West Midlands
Interchange

The West Midlands Rail Freight Interchange Order 201X

Applicant's Post Hearing Submissions (ISH1 – Draft DCO and DCOB 28.2.19) – Document 9.1

ISH1 Agenda Annex 2 - Draft DCO – Structure, Definitions and Articles 1 – 49 (Agenda item 4)

B4 - Proposed Road Bridge, Over Existing Canal (Elevation E4)
(Scale 1:100)

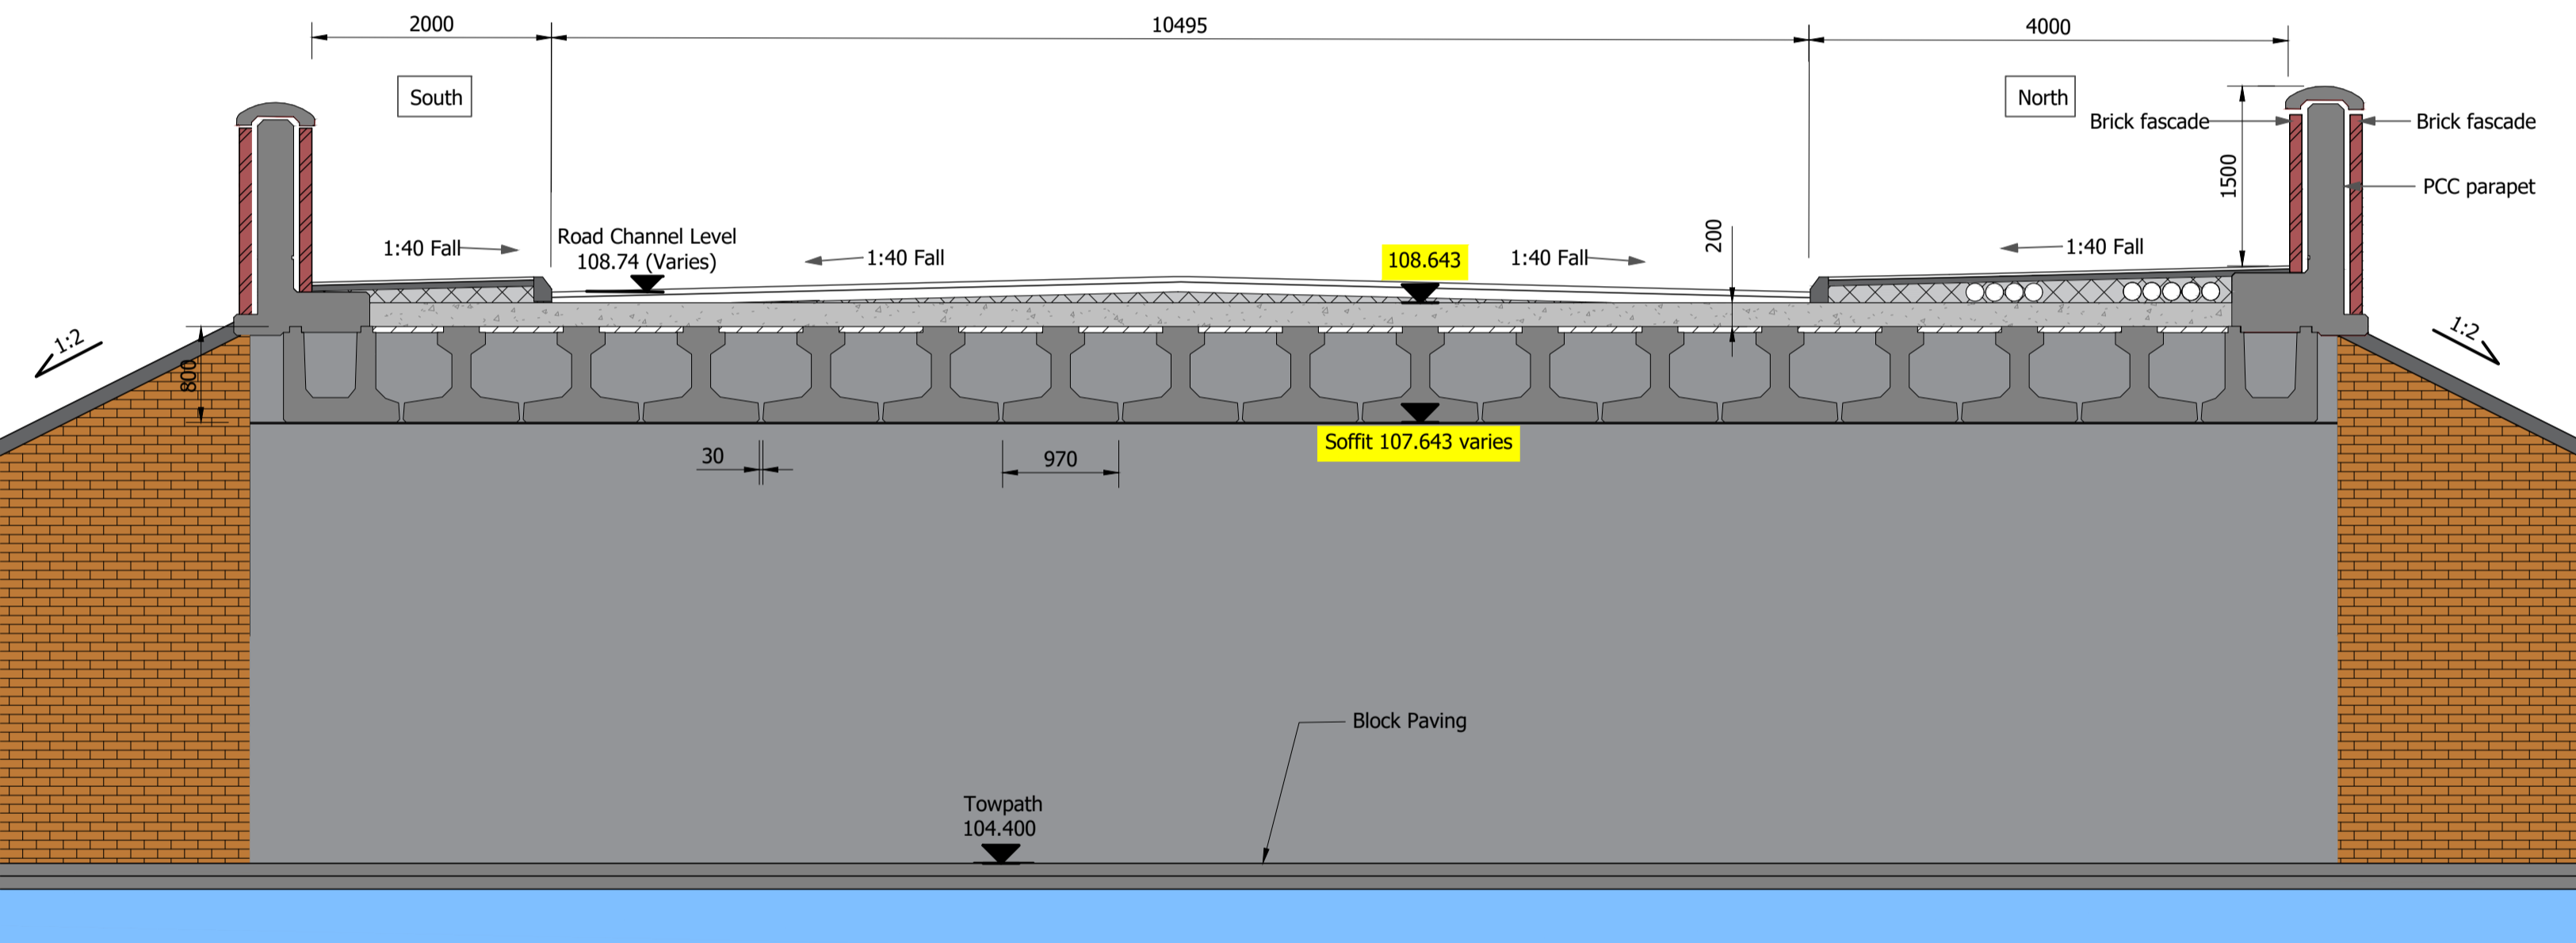
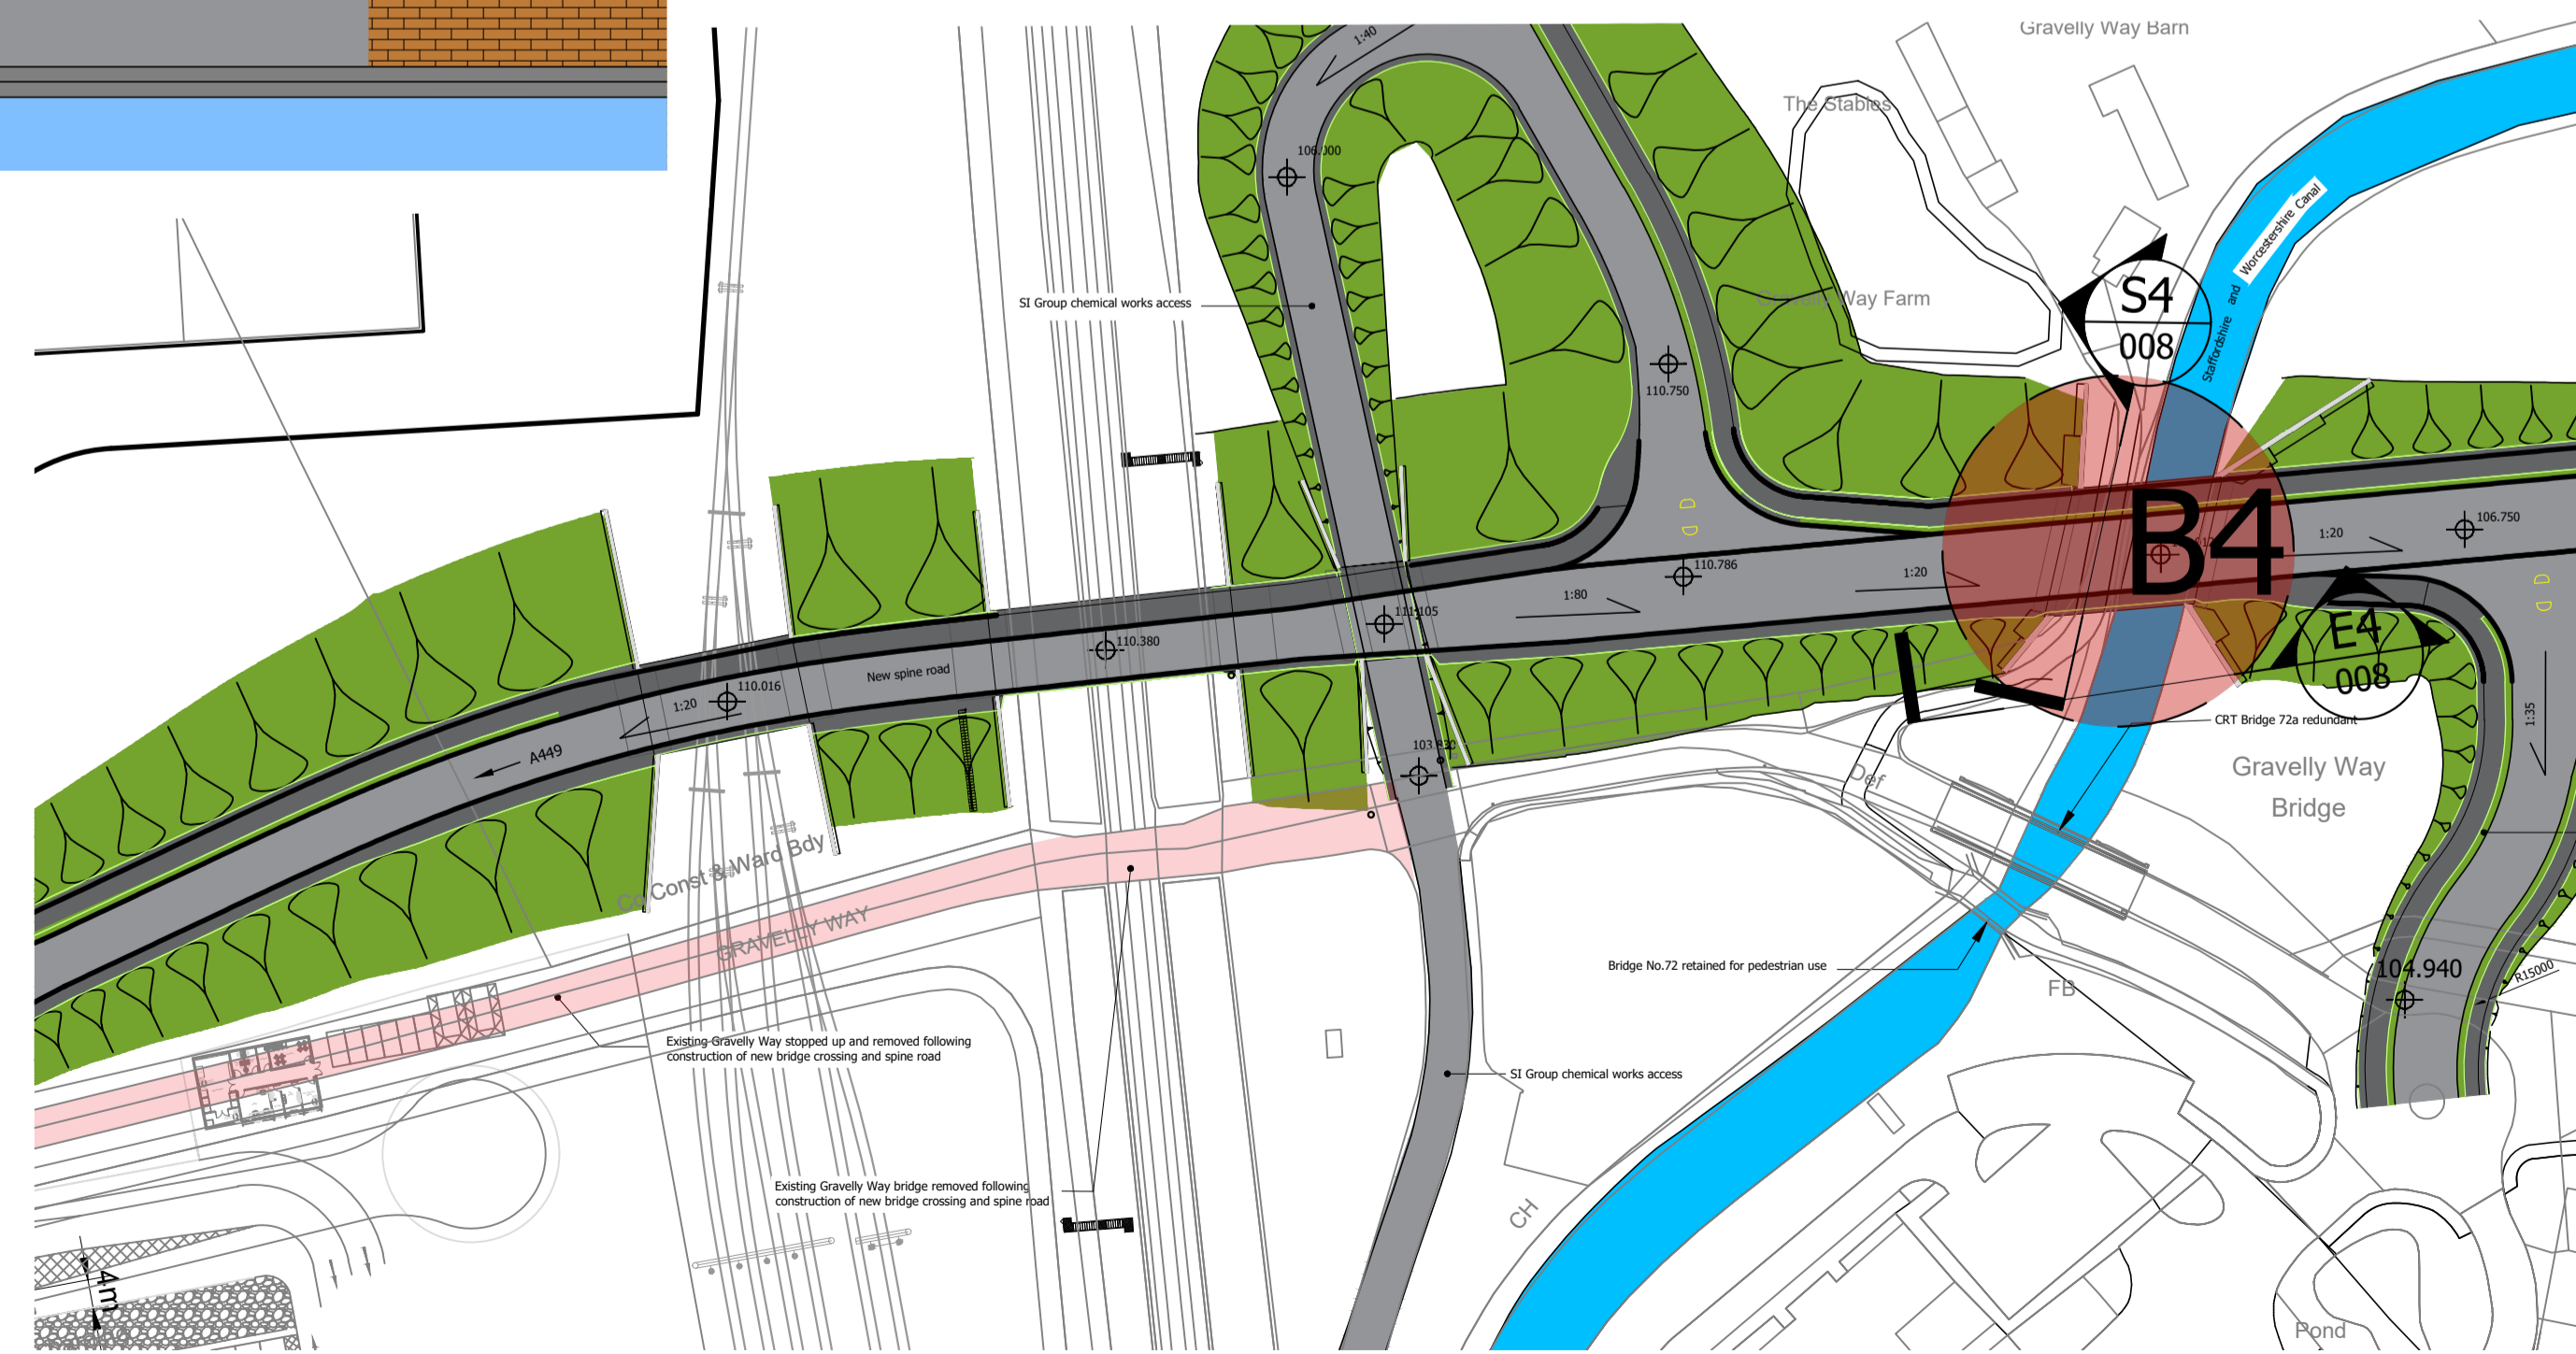
1.10	A4	Applicant	<p>i) How would Clause (b) operate alongside the annotations on the Bridge Plans which indicate detailed levels for the underside, deck and other key elements of the proposed bridges and set minimum clearance levels for the underside of bridges?</p> <p>ii) Would there be a risk that the flexibility provided by Clause (b) might operate in tandem with that provided by Clause (c) (i.e. in relation to a bridge over part of the railway works) to result in an upwards deviation in the level of such a bridge by 3 metres?</p>	<p>i) It is intended that the exact detail of the bridge design is to be approved before construction (requirement 3 will be amended to provide for that explicitly). The ExA will note that some of these annotations on the Bridge Plans refer to approximate distances. The maximum limits of deviation are required to ensure that the DCO allows for tolerance to accommodate normal variations required when construction details are known.</p> <p>ii) The Applicant does not consider that there is a risk of this, but will consider whether the wording of sub-paragraphs (b) and (c) might be suitably amended to alleviate any concerns. The railway works mentioned in sub-paragraph (c) specifically relate to Works 1 and 2, whereas the construction of the bridges is contained in Works 4. However, the Applicant understands the potential for confusion and suggests that article 4(b) is amended to refer to "bridges" rather than "bridge</p>

Q Ref	Part of DCO	Directed to	Question/ comment	Applicant's Response
			<p>iii) Has the full degree of flexibility provided for in A4 been assessed in the ES on a worst case basis?</p>	<p>works”, since the term “bridges” is defined with reference to the Bridge Plans.</p> <p>iii) The parameter plans make reference to the works plans and these, along with the stated variations in Article 4, have been considered in the ES where effects have been considered on a worst case basis.</p> <p>The Applicant clarified at the ISH that A4 does not permit development beyond the parameters and referred to other DCOs which contain similar provisions, as mentioned in the Explanatory Memorandum. The Applicant does, however, acknowledge that there needs to be a clearer relationship between the drafting of A4 and the Bridge Plans, specifically which measurements on the Bridge Plans the tolerance applies to.</p>
